**CITY OF ALBUQUERQUE
Planning Department
November 14, 2007
DRB Comments
2nd Set**

PROJECT #1006922

RE: Lot 27-A/spbp....second set of comments

RE: Lot 27-A/spbp & minor plat

sheet no:
A-2.0

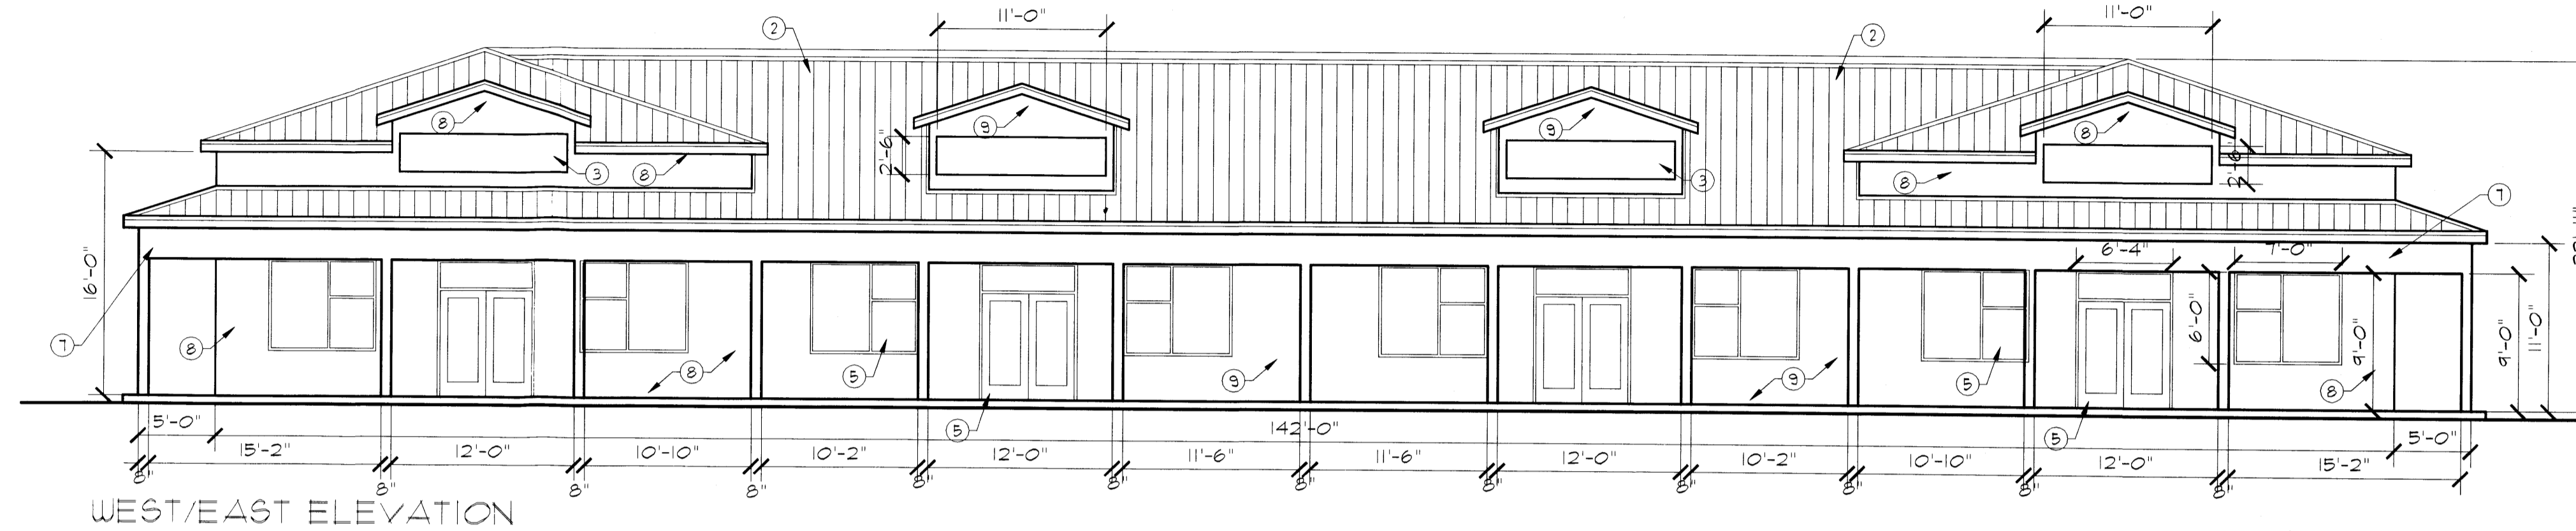
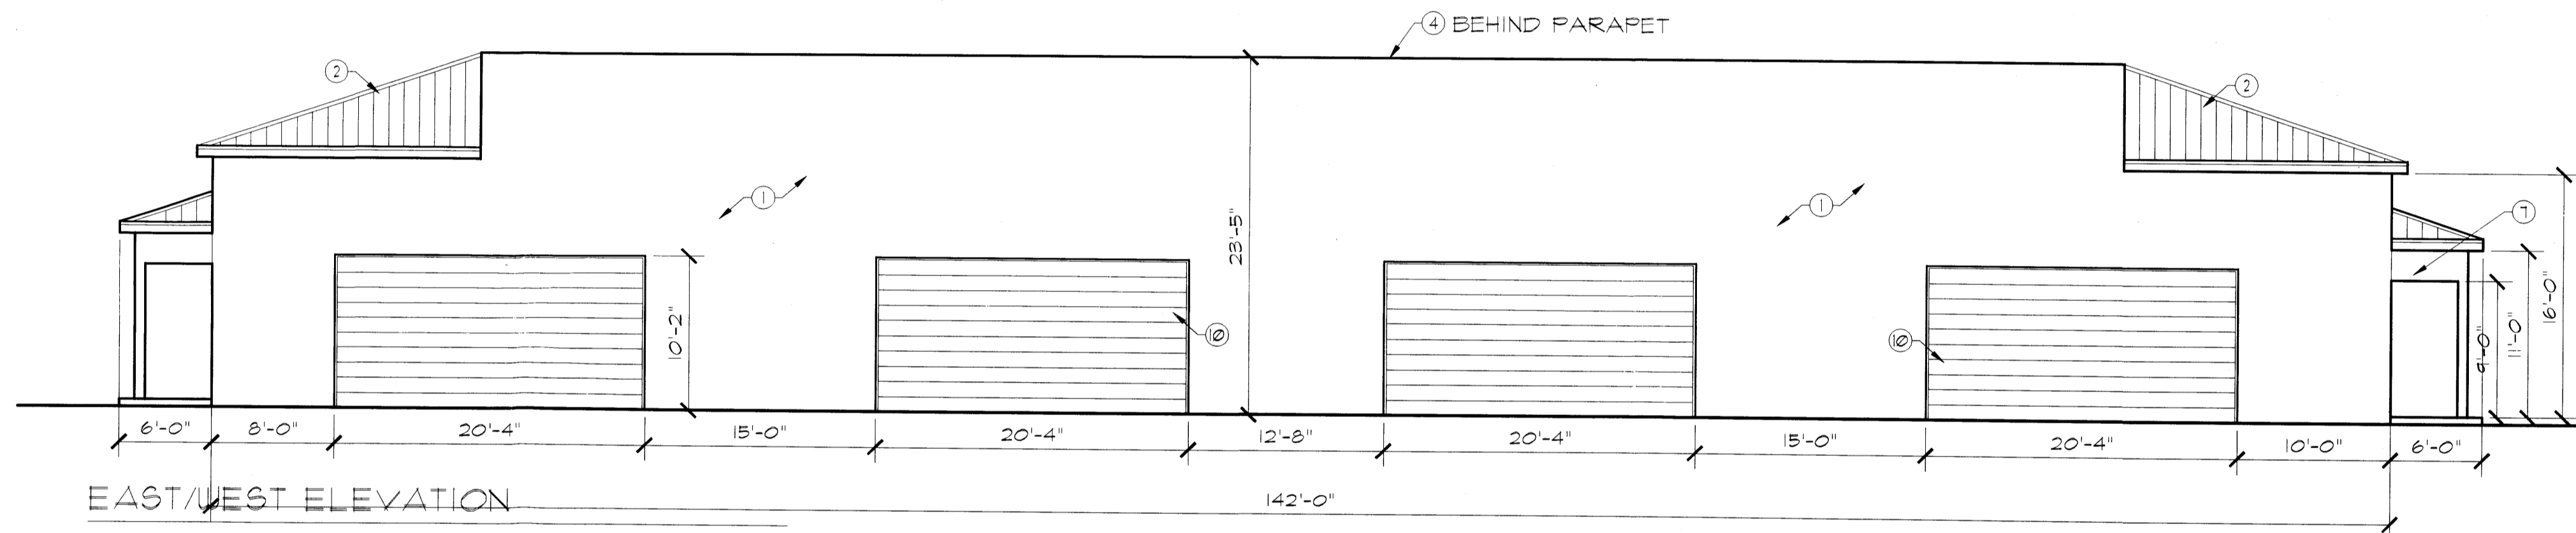
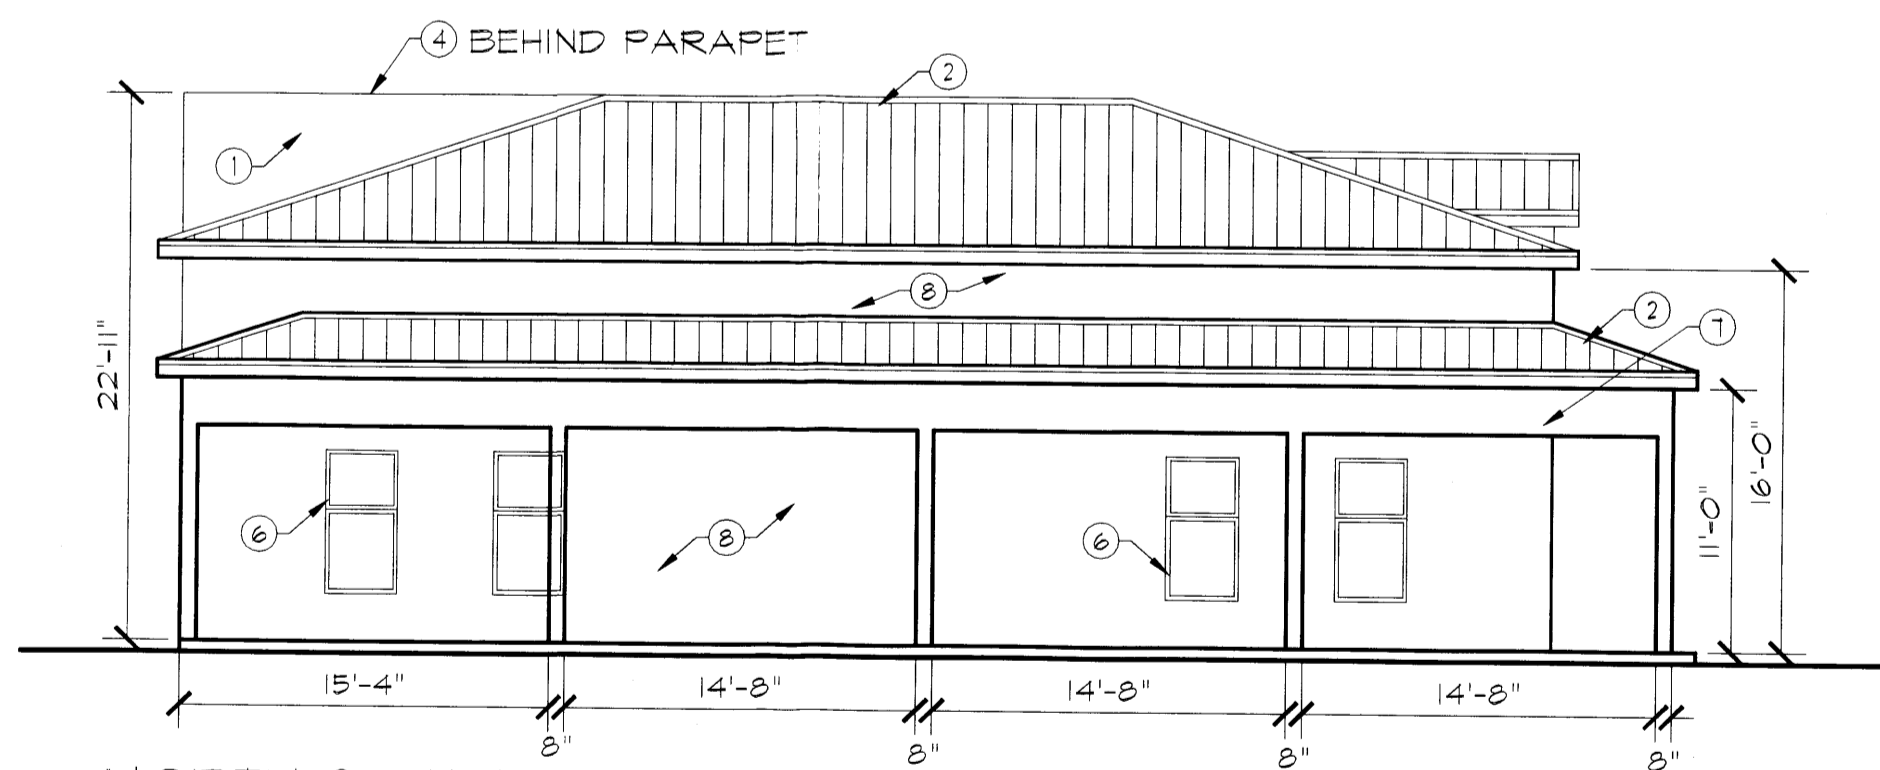
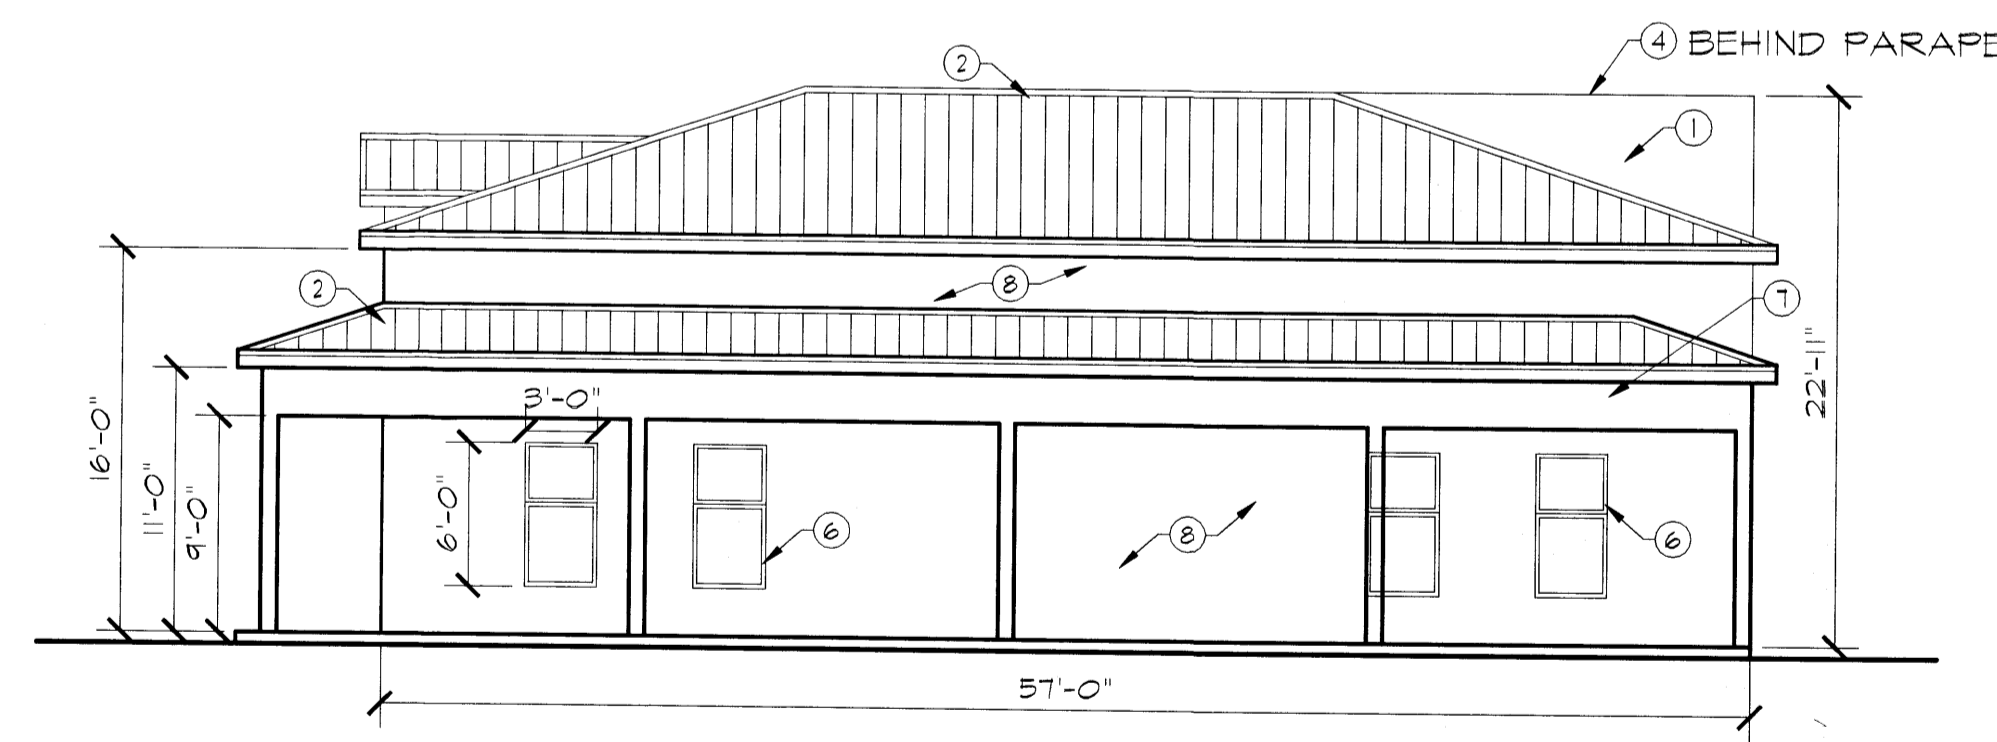
6. The building elevations are still not complete. The color renderings do not satisfy this requirement. Consult the SPBP Checklist for the requirements.

1. The building elevations sheets are not complete. The SPBP Checklist indicates required elements.

2. Remove the floor plans. They are not part of the DRB approval process.

MONUMENT SIGN

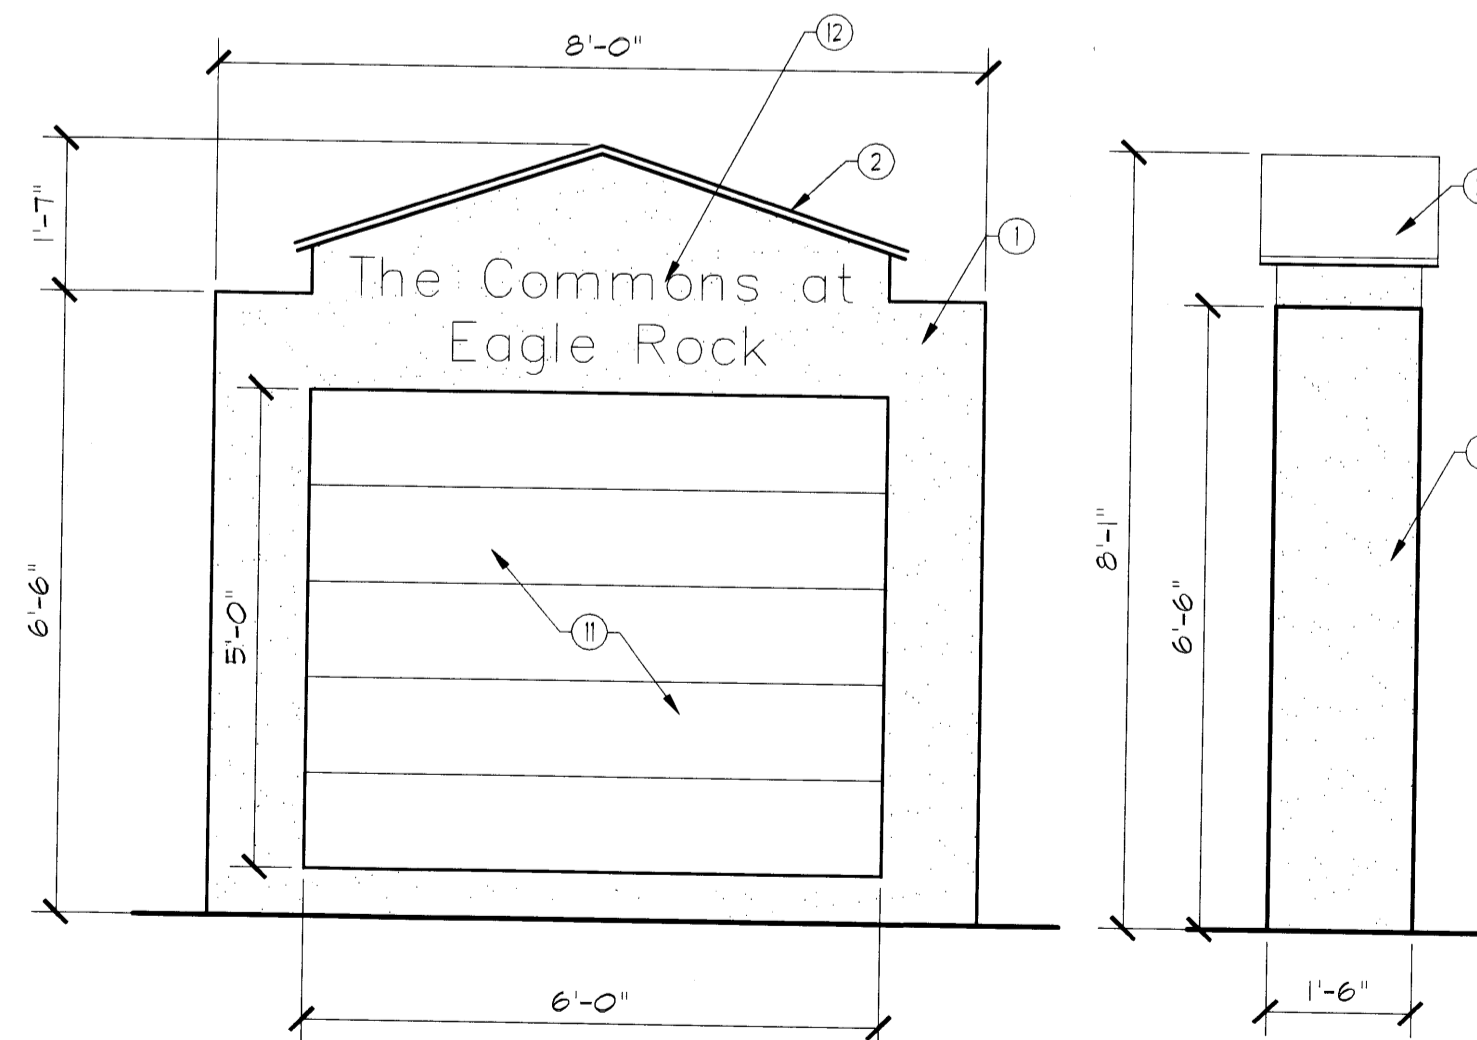
1. The colors of the monument signs and size & colors of the letters and what the sign will say are required.

REFUSE ENCLOSER

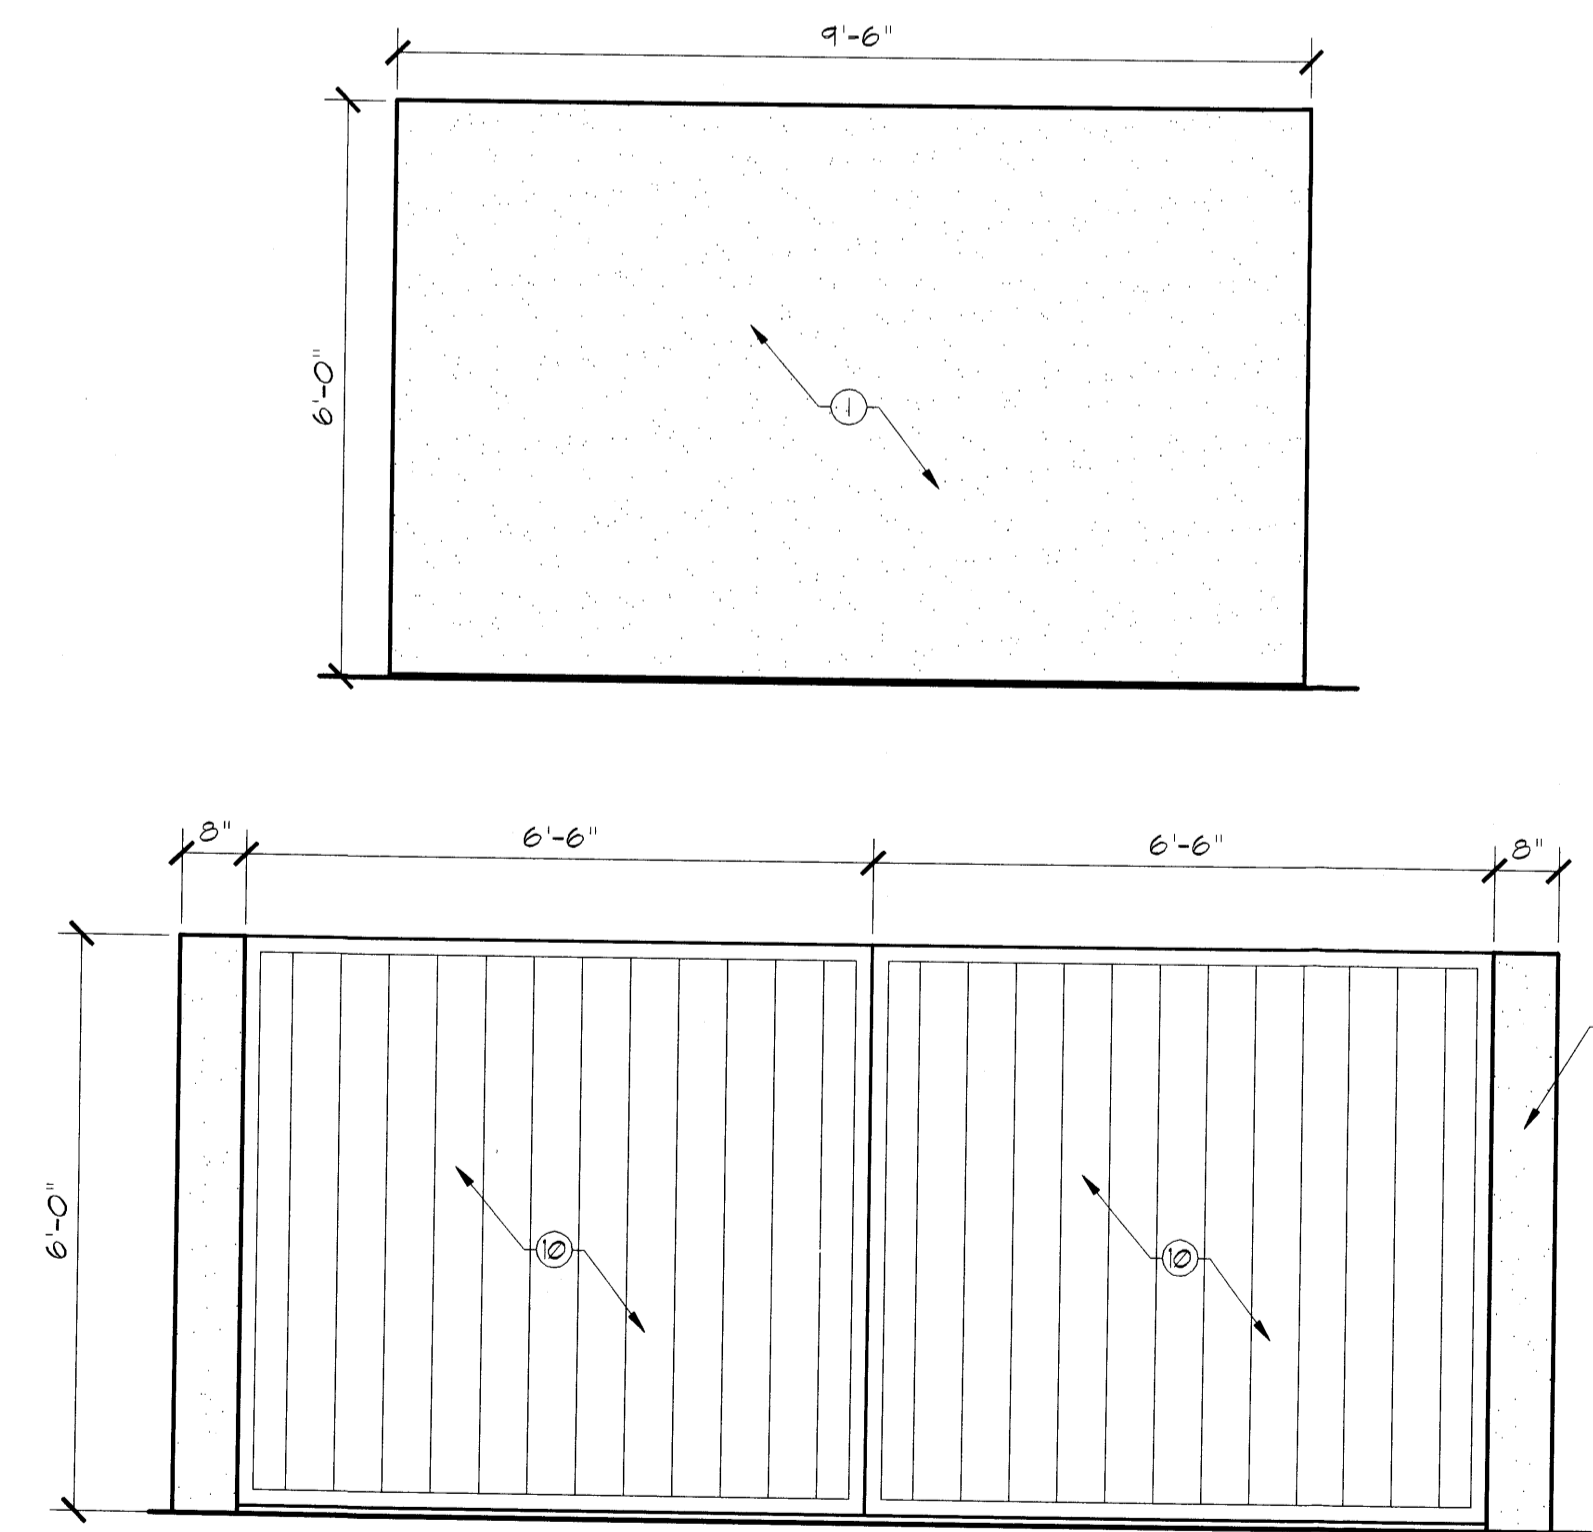
7. Wood pickets are not allowed in the refuse fence or gate. Steel ones are required.

3. The elevation drawing of the refuse container and enclosure is missing. Page 53 of the North I25 Sector Plan has requirements.
